Our Ref: STH10/00063/08
Contact: Chris Millet (4221 2570)
Your Ref: MP09_0088

**SHOALHAVEN CITY COUNCIL – MAJOR PROJECT 09_0088 – MIXED USE SUBDIVISION,
WEST CULBURRA**

Reference is made to your email dated 24 April 2014 regarding the subject project application forwarded to Roads and Maritime Services (RMS) for consideration.

PRELIMINARY CONCEPT ROUNDABOUT 01 DESIGN
WEST CULBURRA MIXED USE DEVELOPMENT
 Over Lot 1 DP 1305809 (CONCEPT DA)
 At CULBURRA ROAD, CULBURRA BEACH
 For SEALARK PTY LTD

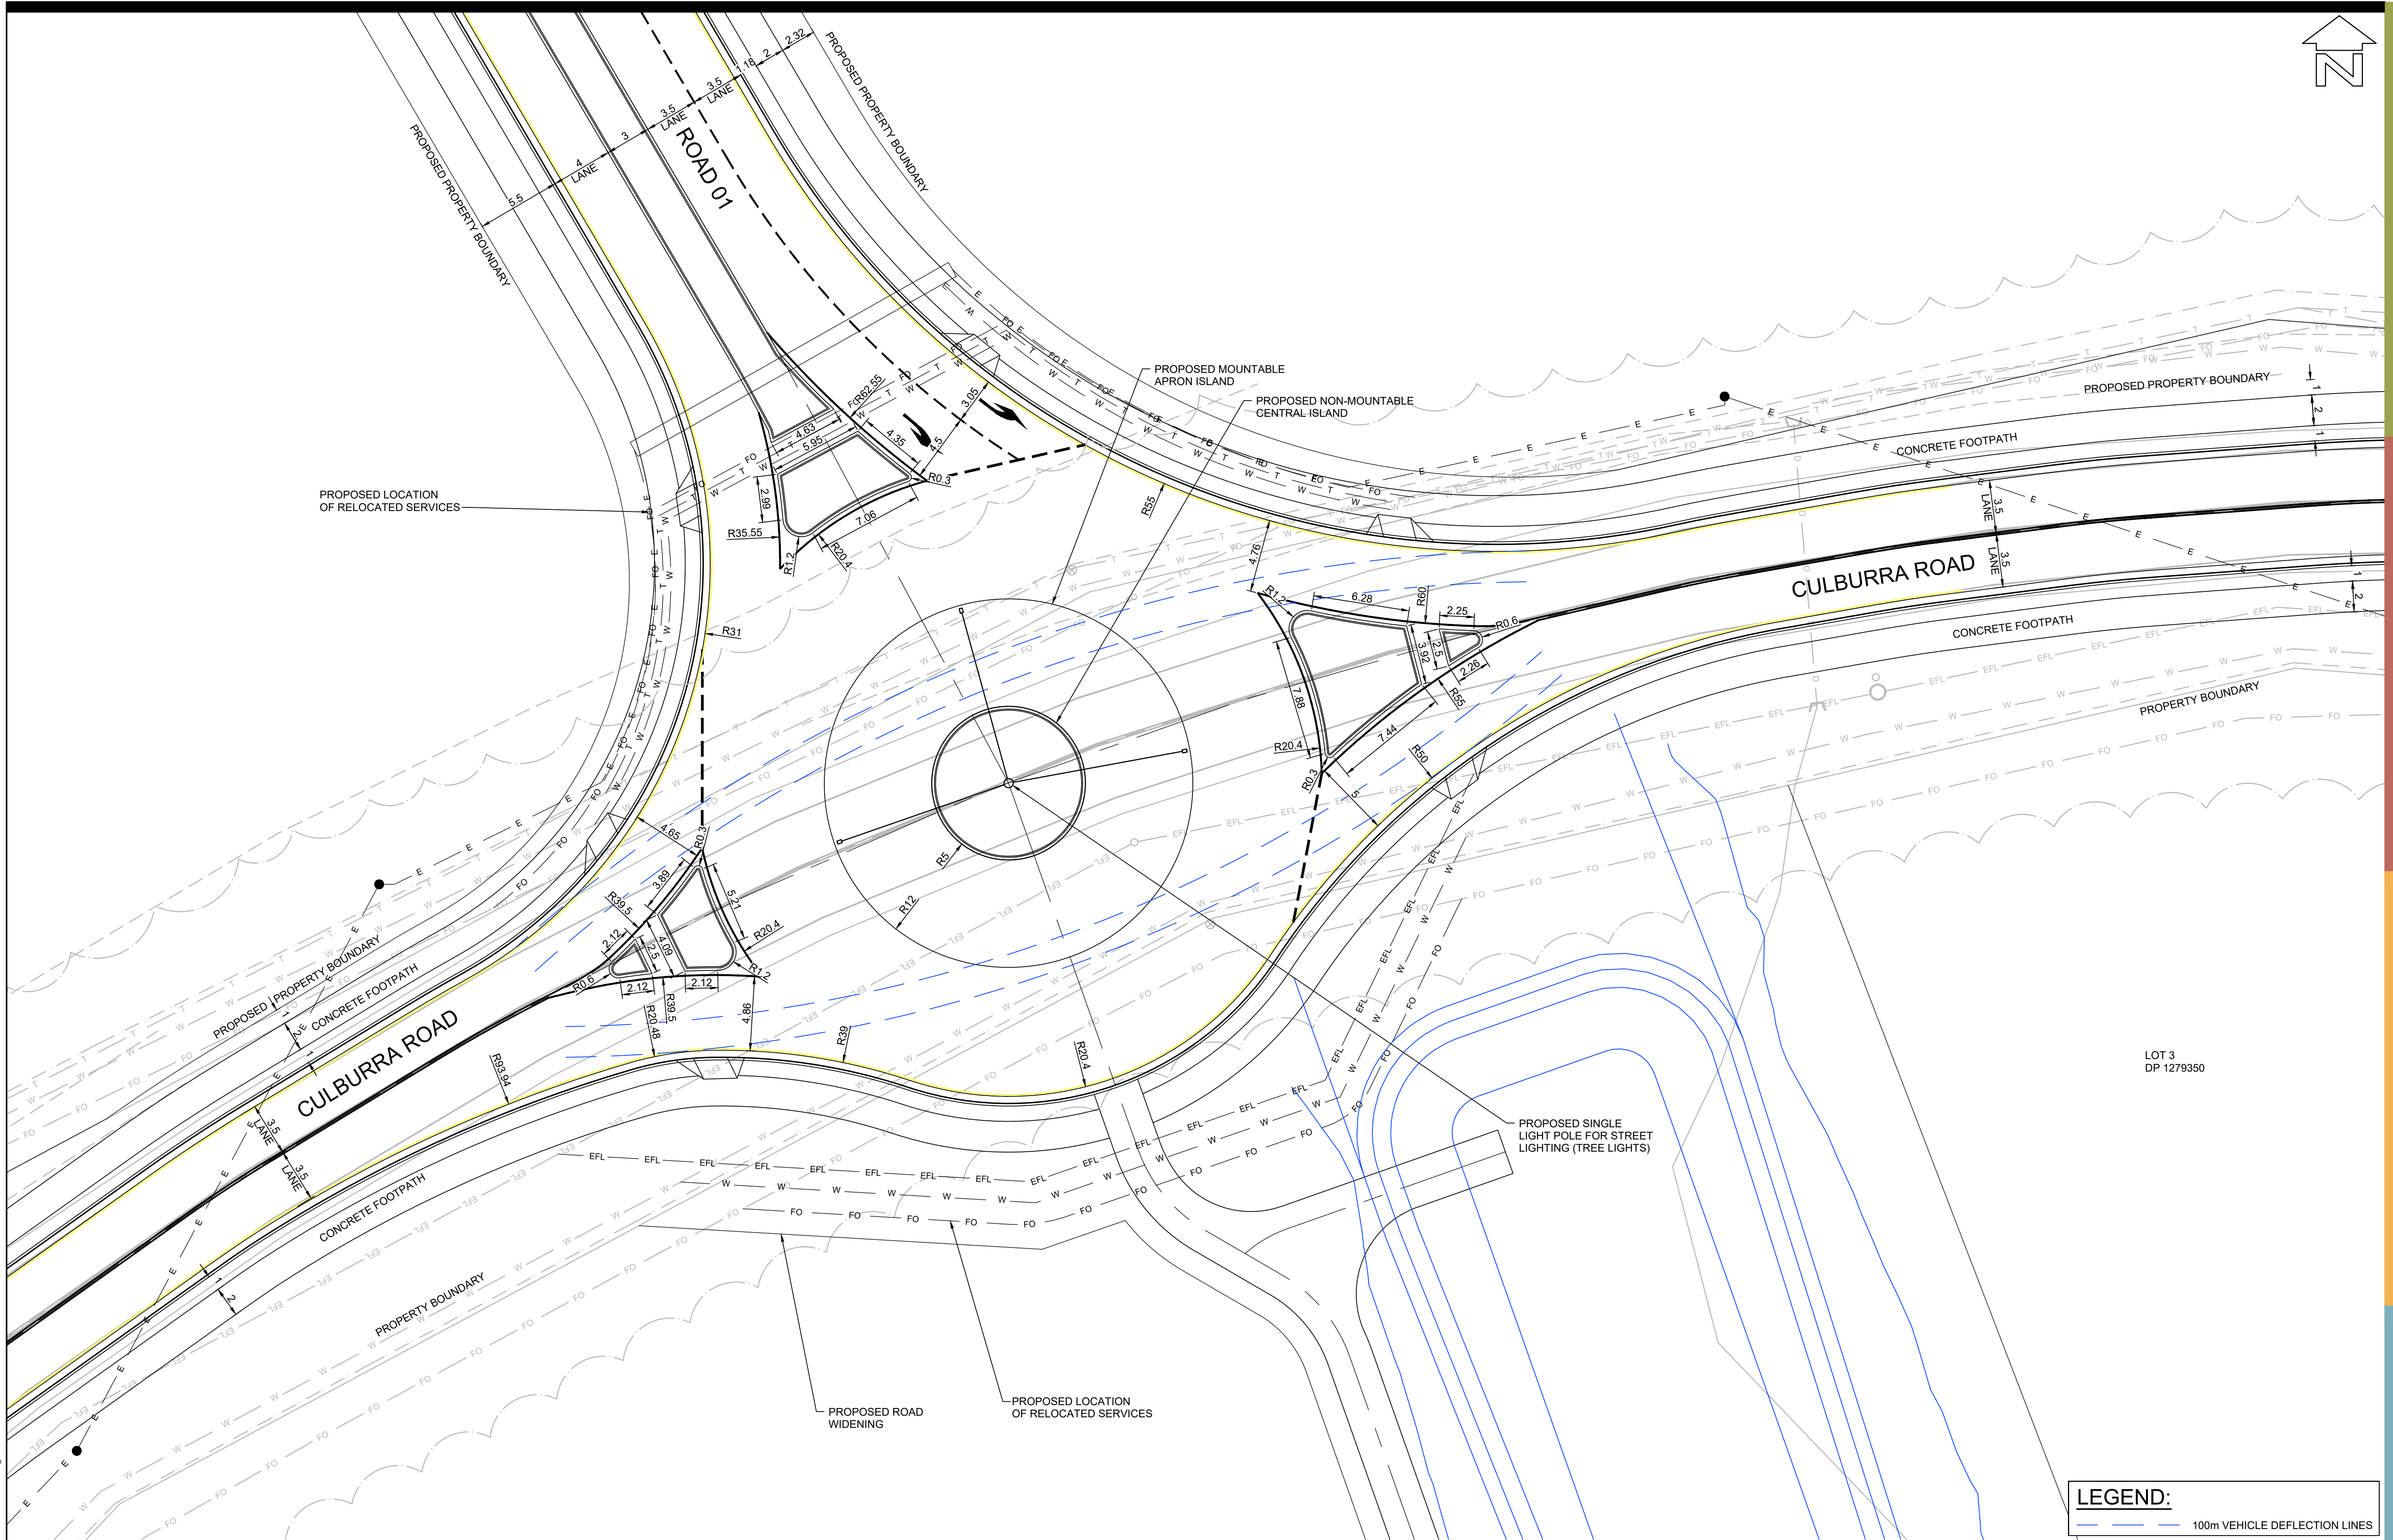
RMS has reconsidered its position and would accept a roundabout and the associated necessary speed reduction to 80km/h to facilitate access to the development subject to the following:

- The proponent identifying, and committing to a suite of measures on Culburra Road prior to determination of the project to reinforce the change of environment from a rural environment to an urban environment. This would need to commence on the eastbound appropriate to the roundabout and continue through the roundabout into the existing township.

PRELIMINARY ROUNDABOUT 01 SIGHT LINE LAYOUT PLAN

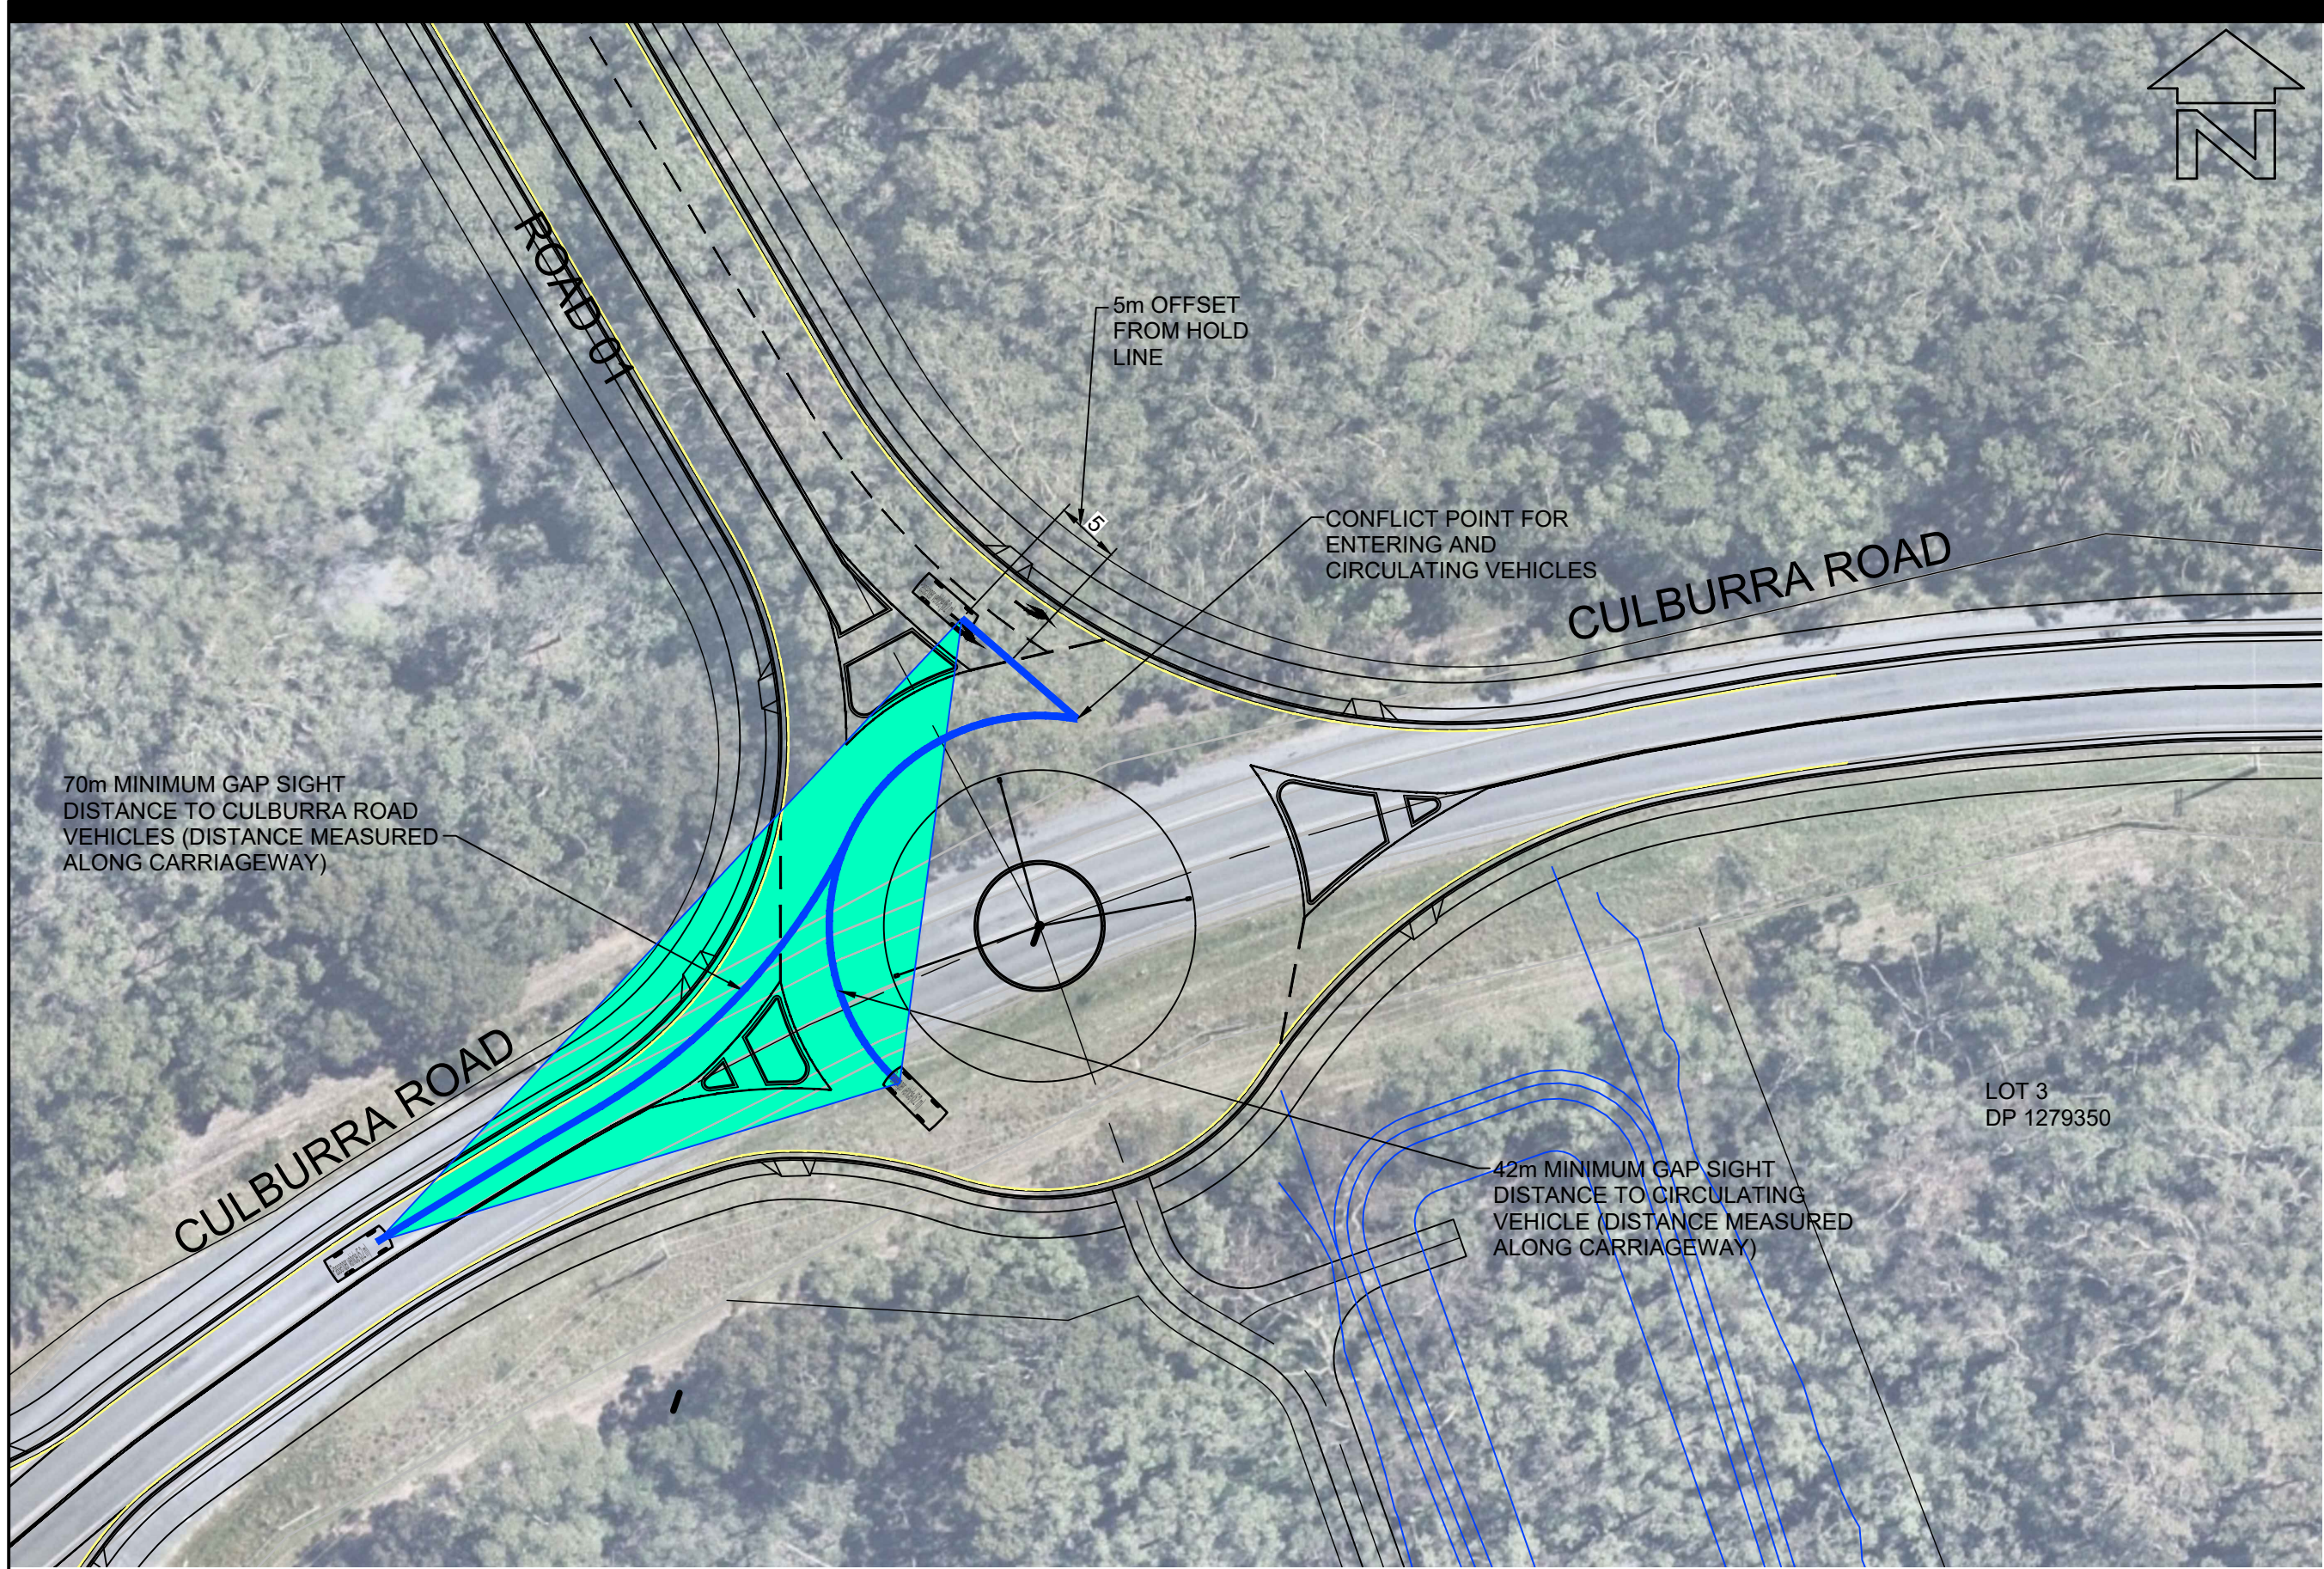
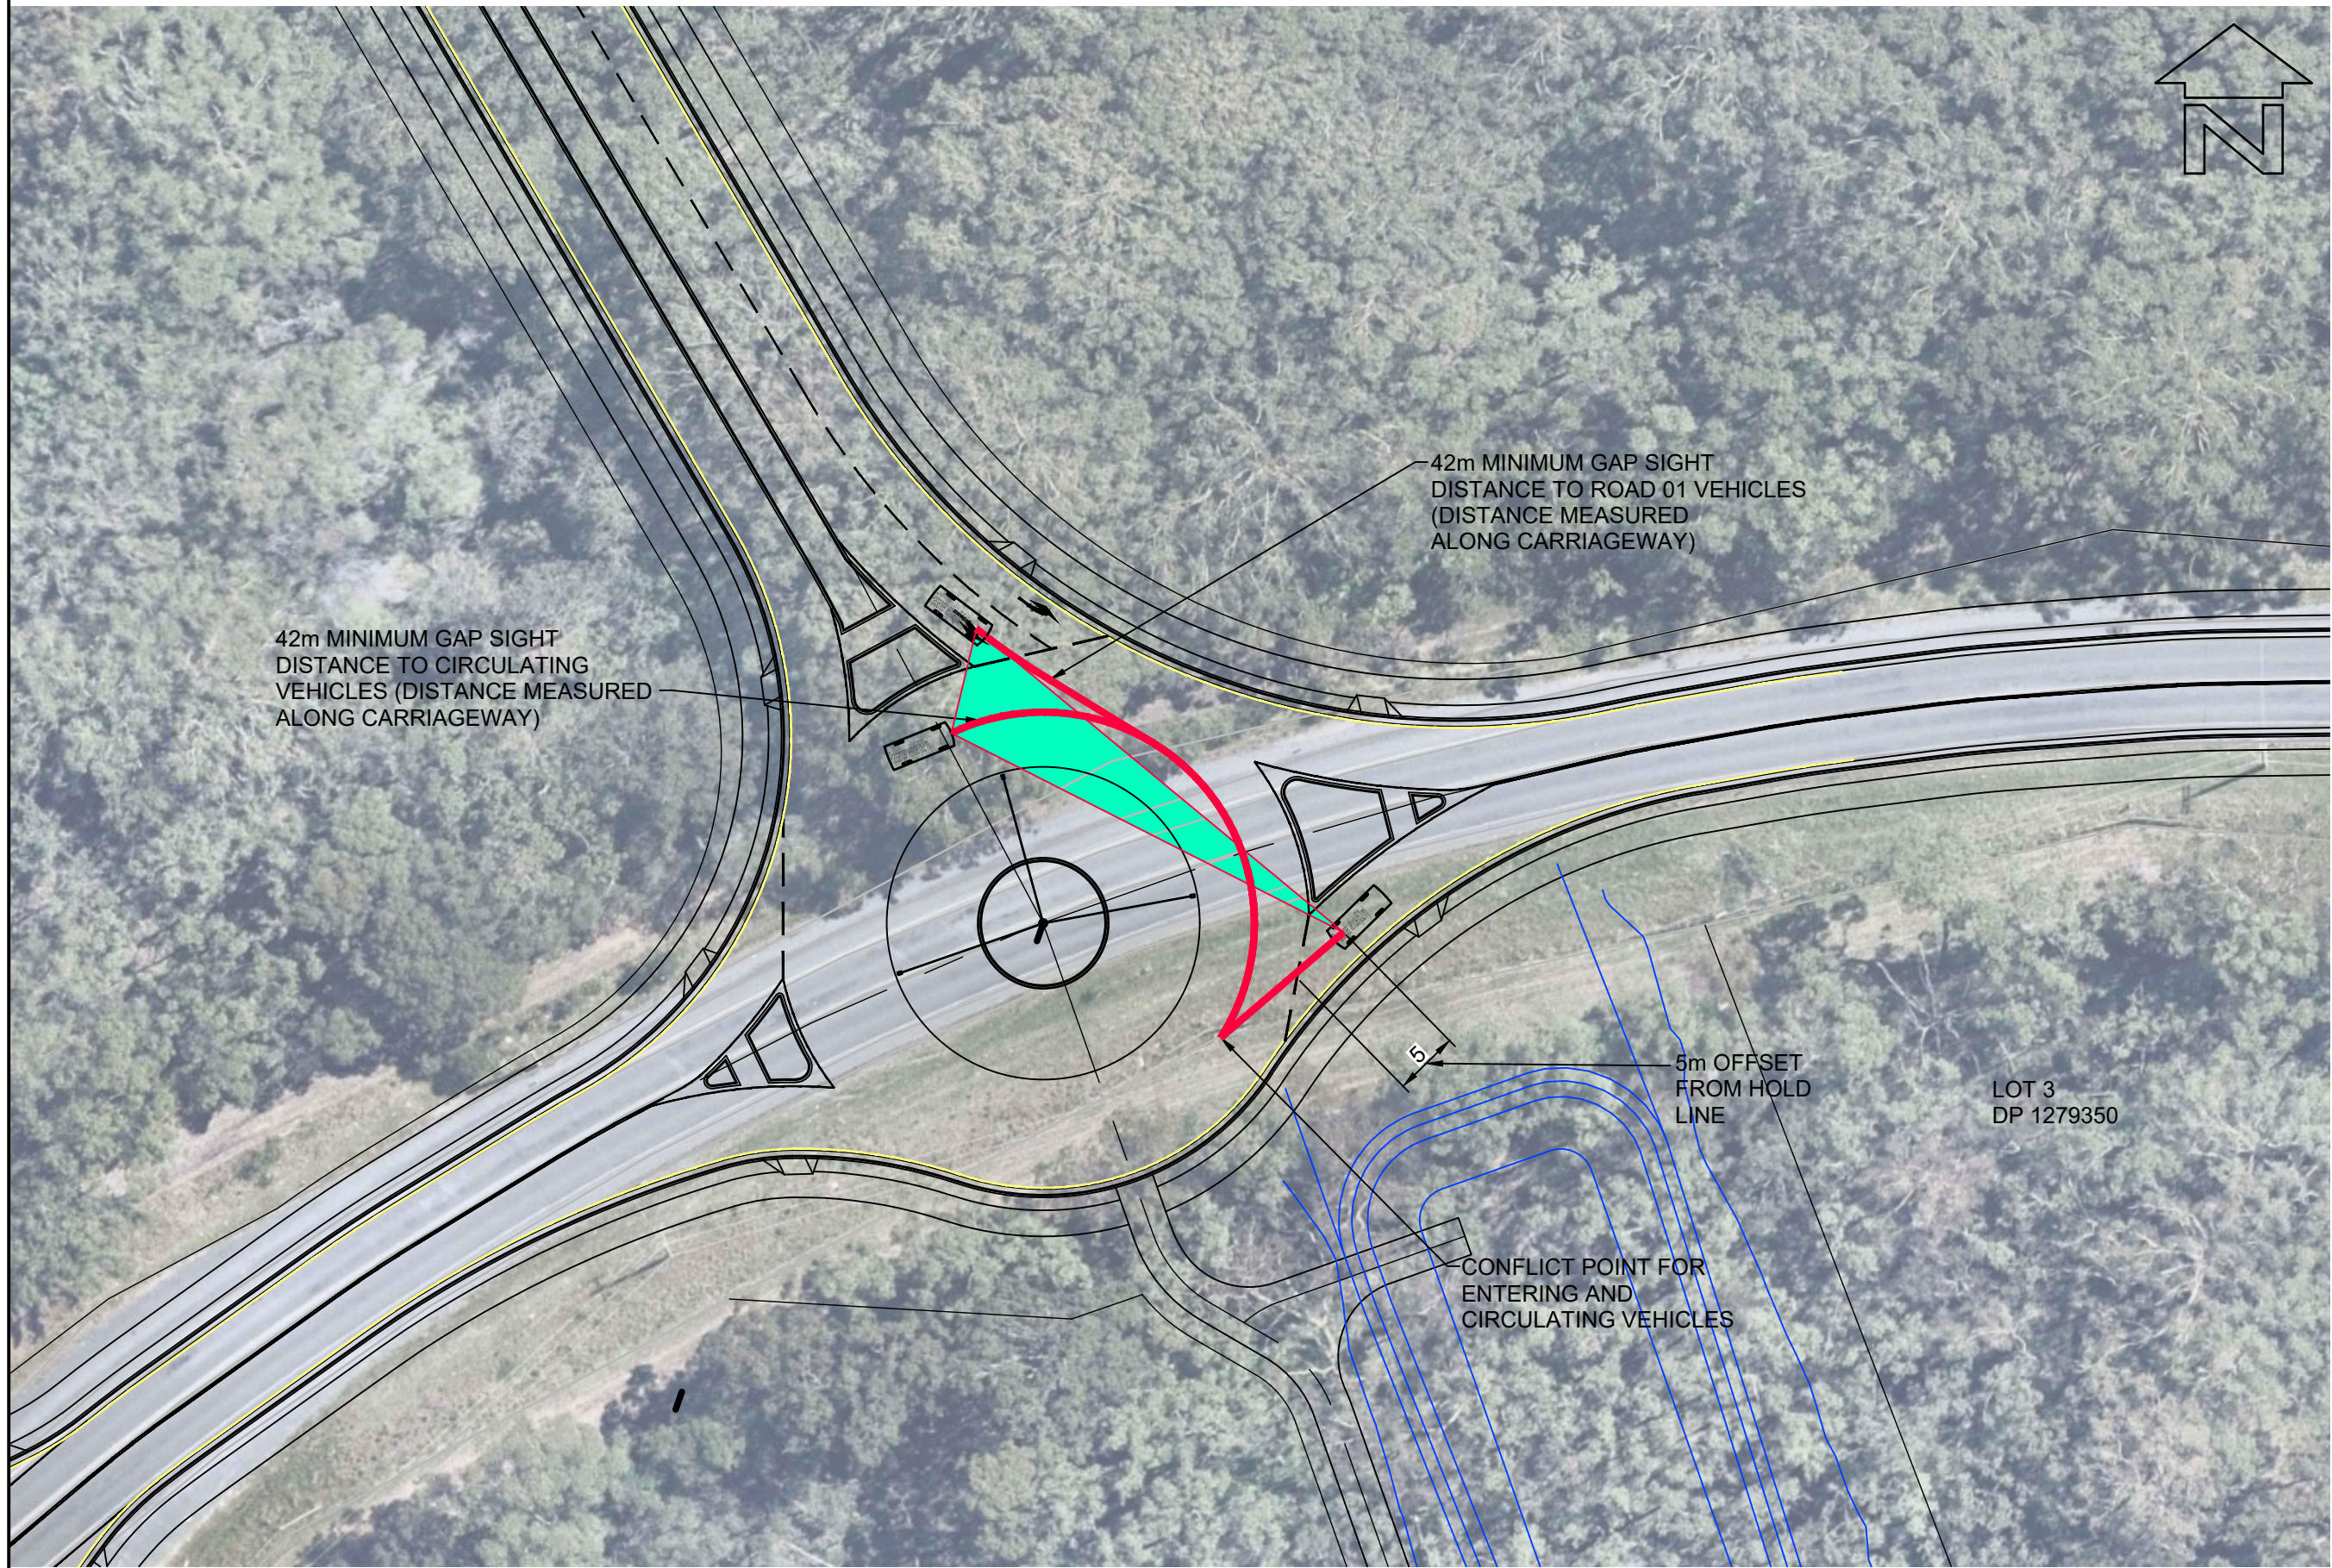
- The proponent providing a design which demonstrates that appropriate sight distance will be available to roundabout prior to determination of the project. Given that the roundabout will be located immediately after the transition from the 100km/h speed zone, RMS considers that the design speed for sight distances needs to be 10km/h above the intended posted limit. Therefore sight distance will need to comply with Austroads standards for a 90km/h speed environment. This includes appropriate sight distance to the layout of the roundabout for both eastbound and westbound vehicles. The location of the roundabout and demonstration of compliance with sight distance requirements would need to be based on survey and design.
